From: Outhwaite, Jackie [jackie.outhwaite@environment-agency.gov.uk]
Sent: 11 January 2012 13:20
To: Mike Longman
Cc: Davies, Gillian; Browne, Glen
Subject: RE: UPPER HEYFORD - DISCHARGE AUTHORISATION

ENQUIRY REGARDING CONDITION 35 OF 08/00716/OUT (APPEAL DECISION 2080594) FOR OUTLINE APPLICATION FOR NEW SETTLEMENT OF 1075 DWELLINGS, TOGETHER WITH ASSOCIATED WORKS AND FACILITIES INCLUDING EMPLOYMENT USES, COMMUNITY USES, SCHOOL, PLAYING FIELDS AND OTHER PHYSICAL AND SOCIAL INFRASTRUCTURE. HEYFORD PARK, CAMP ROAD, UPPER HEYFORD.

**POL 23A AND 23B, QUICK REACTION ALERT AREA, UPPER HEYFORD,
OXFORDSHIRE**

Applicable to the following tanks: POL 23A, POL 25B

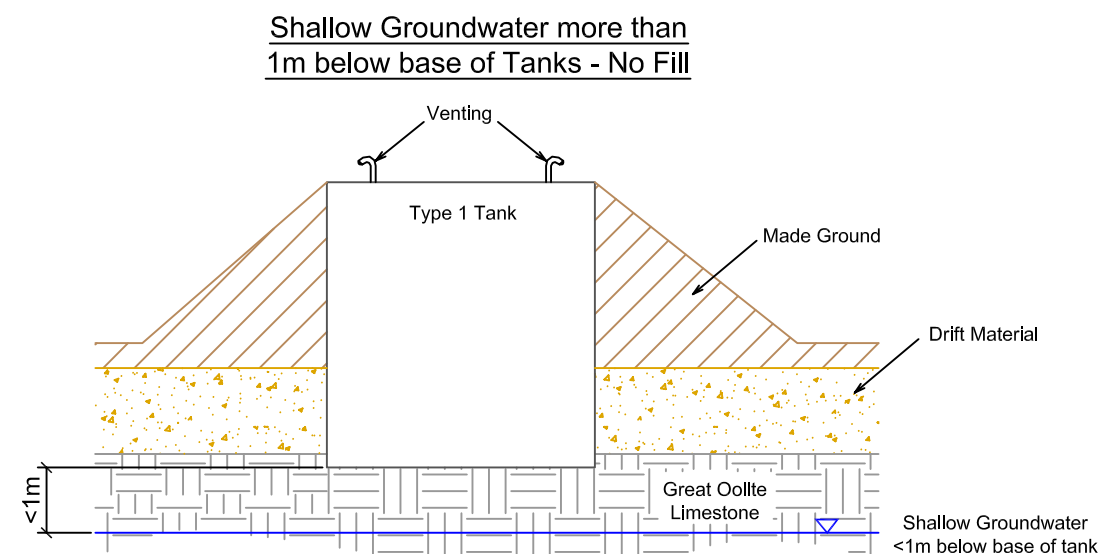
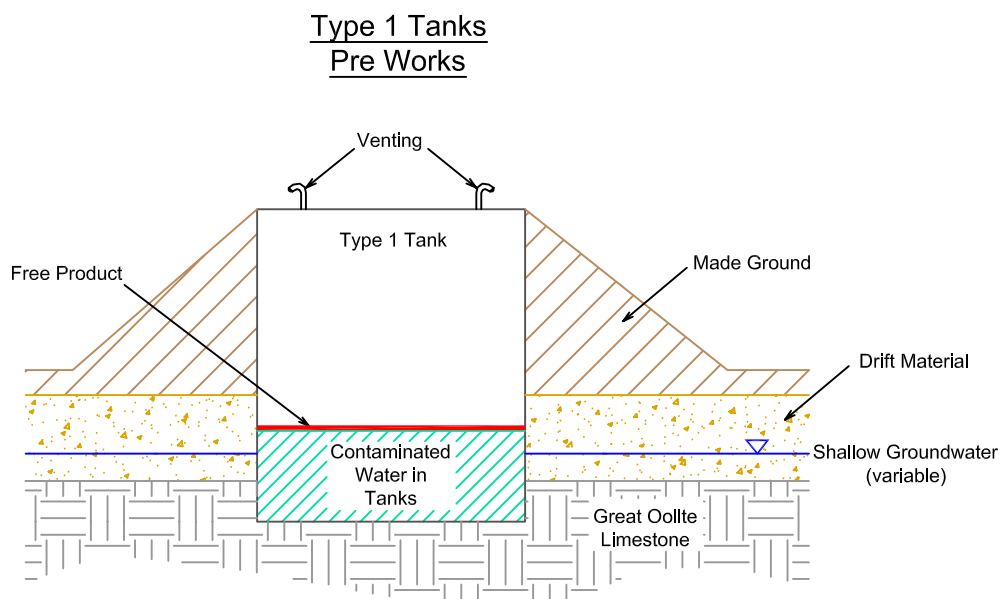
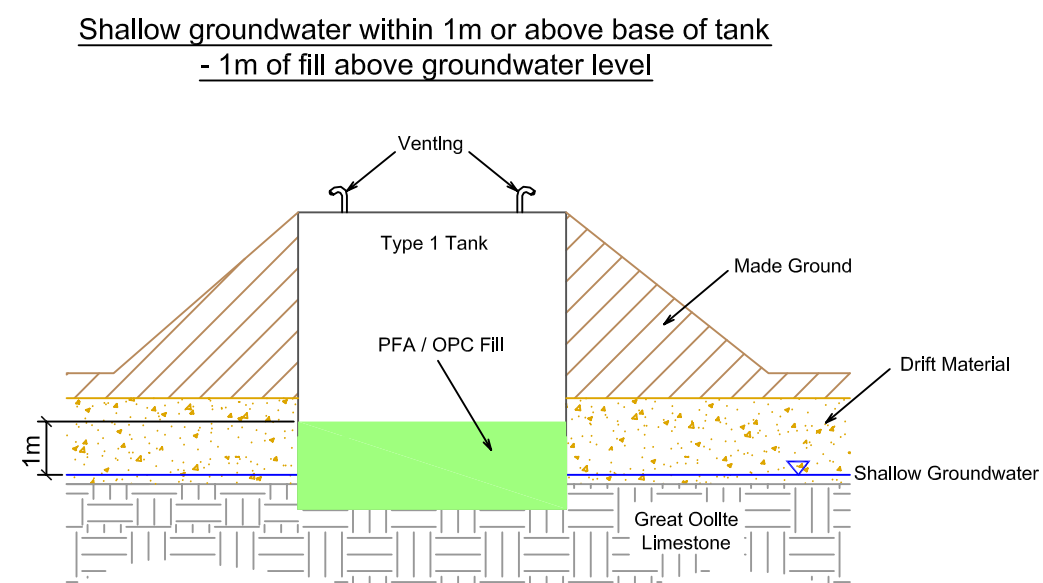
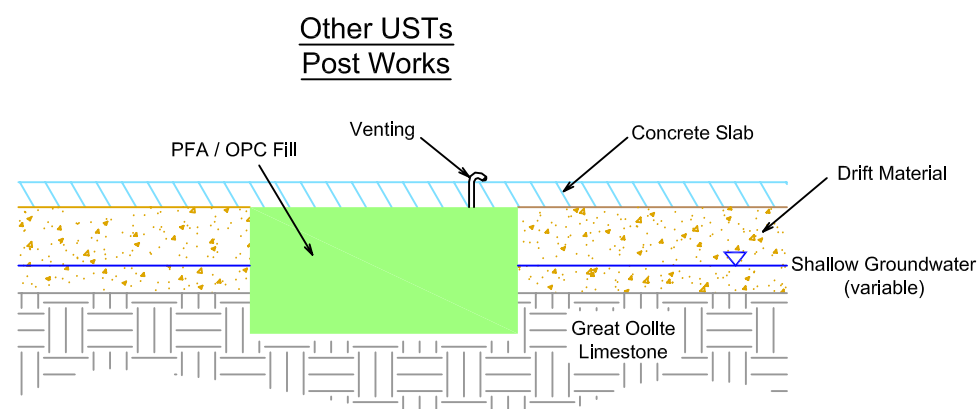
Groundwater monitoring results provided by Watermans show that 318 µg/l TPH has been detected in BH217 in the location of the southern bomb store. It is proposed to fill POL 25b with PFA/concrete mix and this POL station is located to the west of BH217. Therefore, before we can agree to the filling of POL 25b, we need to see details of groundwater flow in this vicinity. Condition 35 states that in the case of gross

contamination, tanks should be removed to remediate under the tank. We need to be confident that there is no association between this POL station and the groundwater contamination.

From a groundwater quality perspective we have reviewed the details of groundwater flow direction in the vicinity of POL25b. This information together with more recent groundwater quality results, showing below detection limits concentrations of TPH at Borehole BH217, means that we are now in a position to agree to the infilling of POL25b with PFA grout.

Dwg: 2862_04

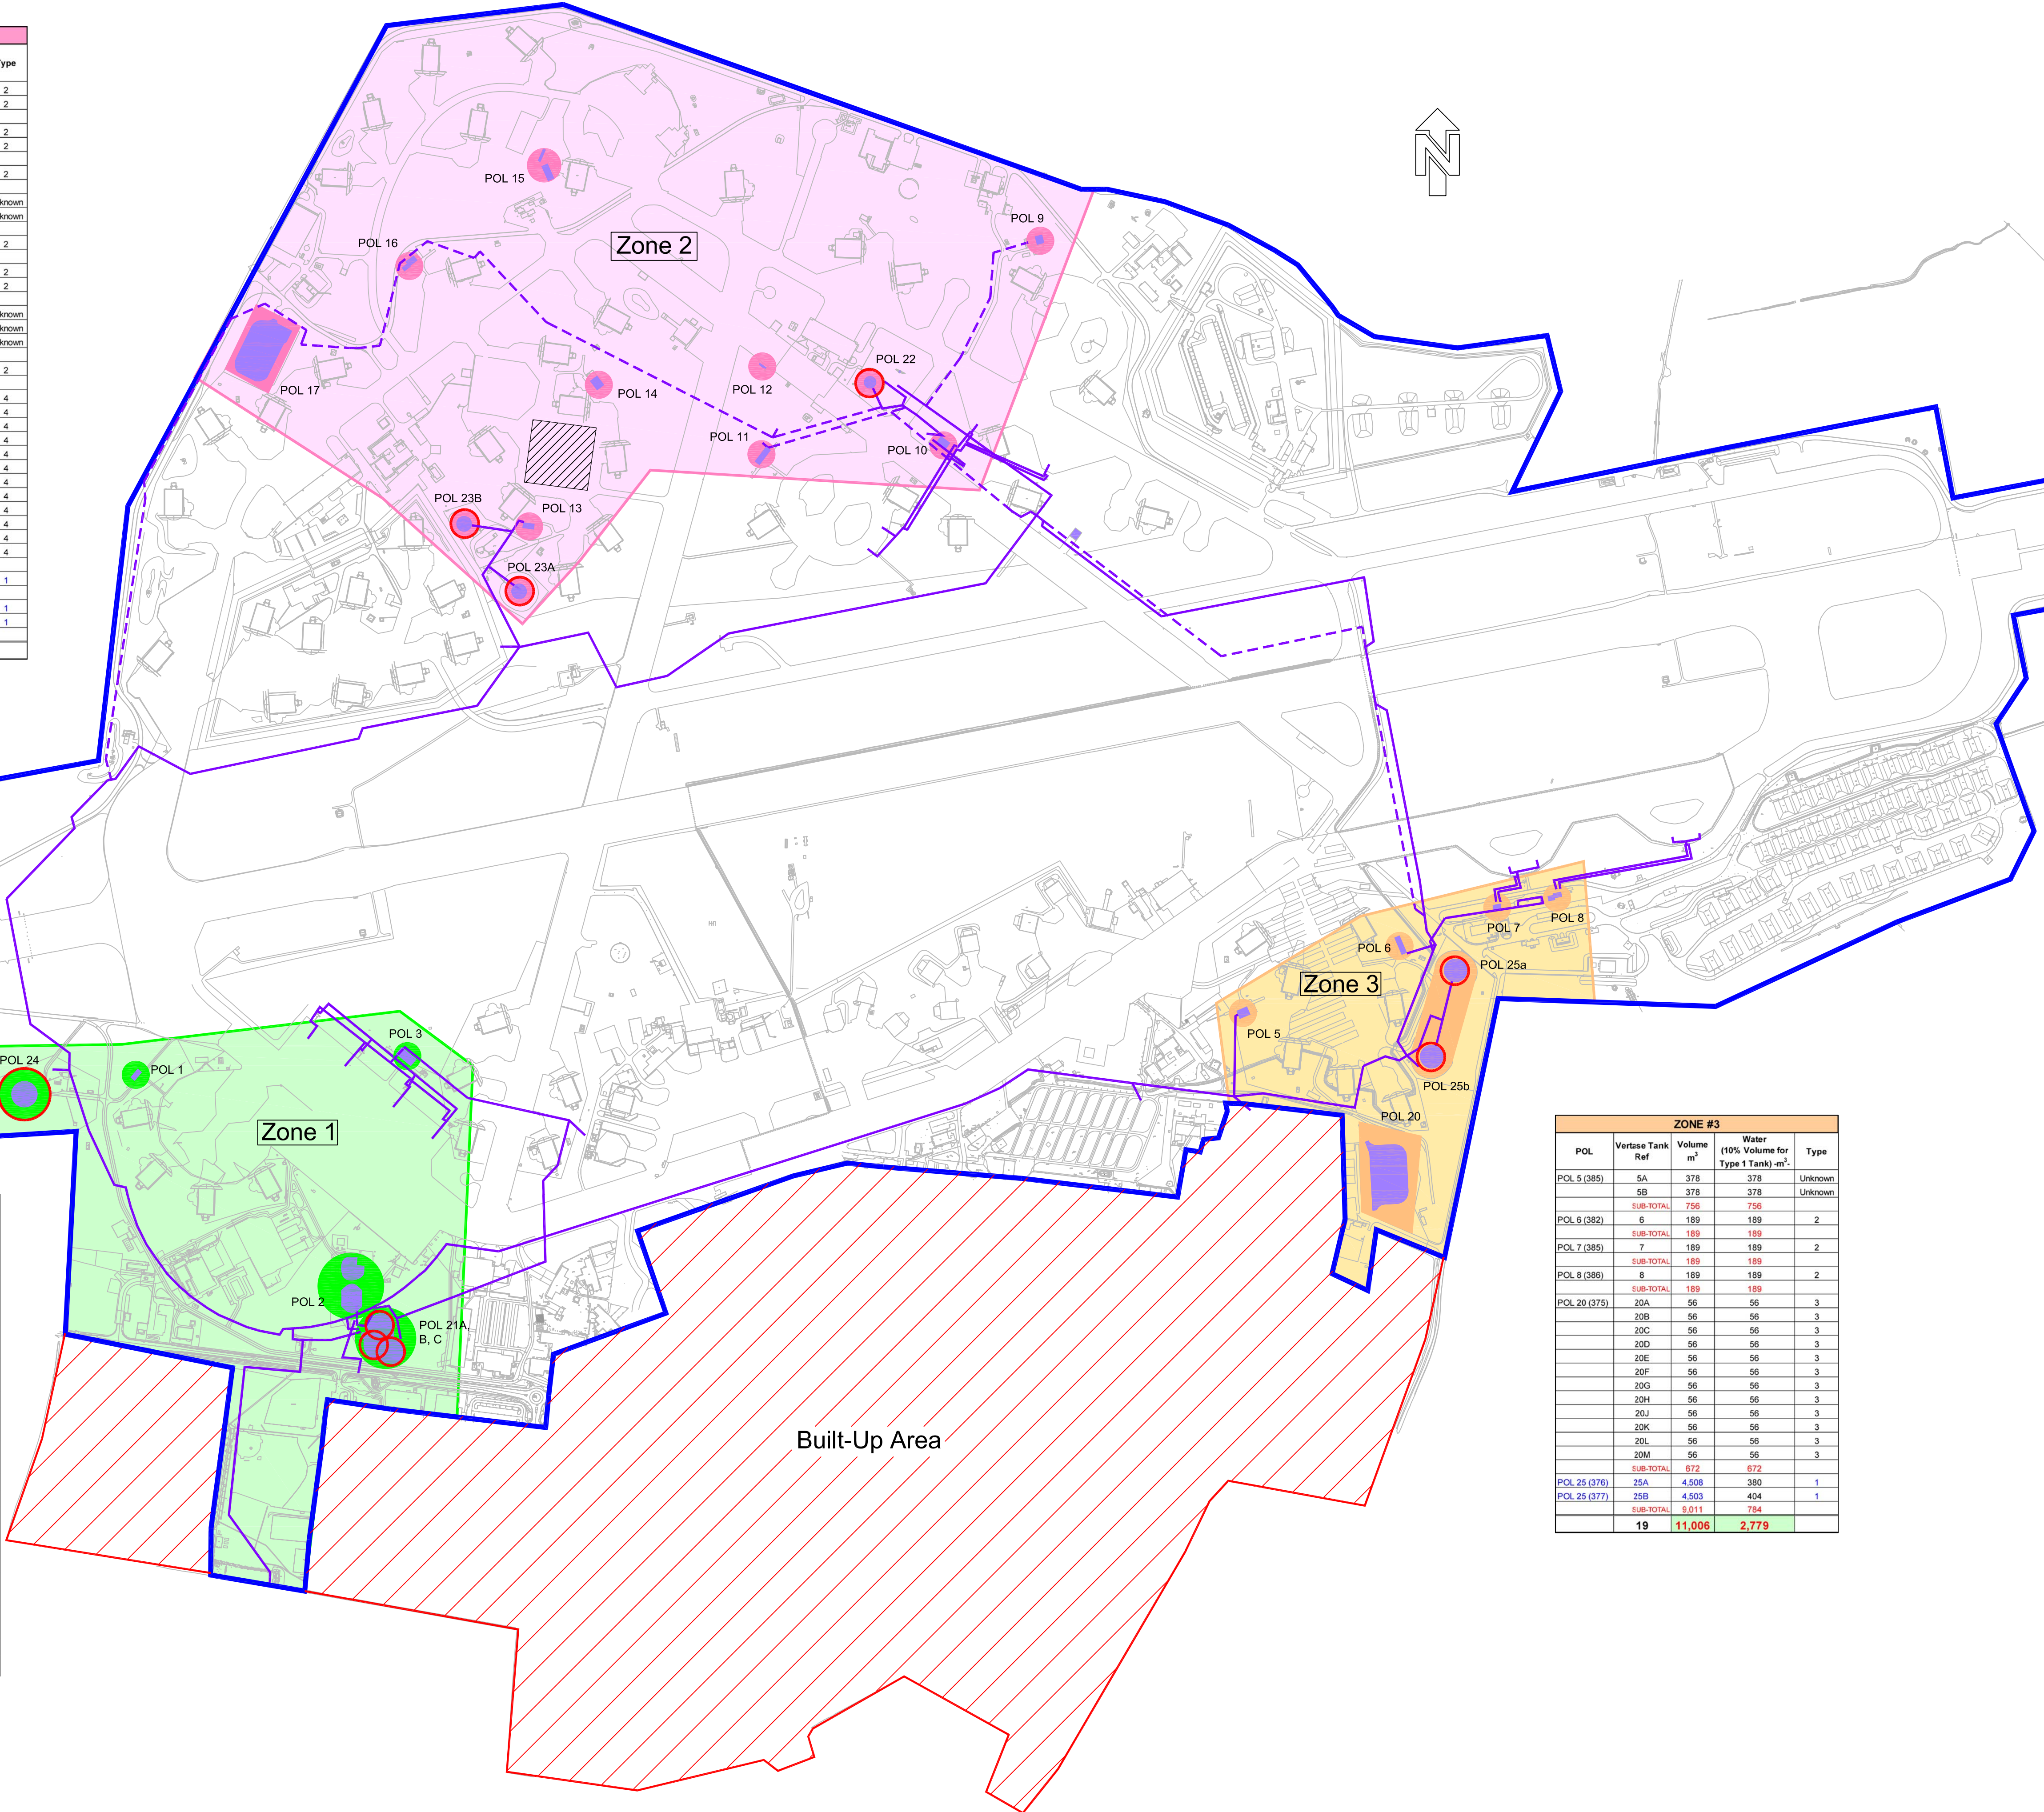
Whilst I have no issue with discharge onto areas 15, 16 and 17, I do have an issue with using area 10. This is in the area of the fuel entry compound and POL21 where fuels spills occurred. Groundwater quality testing at boreholes BH223 and BH224 showed elevated TPH in groundwater (0.302 and 0.243 mg/l respectively). Please liaise with Freddie Alcock at Waterman, for I would prefer that increased infiltration is not used this area.

I had a chance to have a look at the results for Areas 6, 7 and 8 the results of the grab samples look fine. The soil contamination in Area 9 is slightly elevated above those for the other areas. Therefore please restrict your discharge in this area to water from POL 9 only and not from any other tanks in this area.
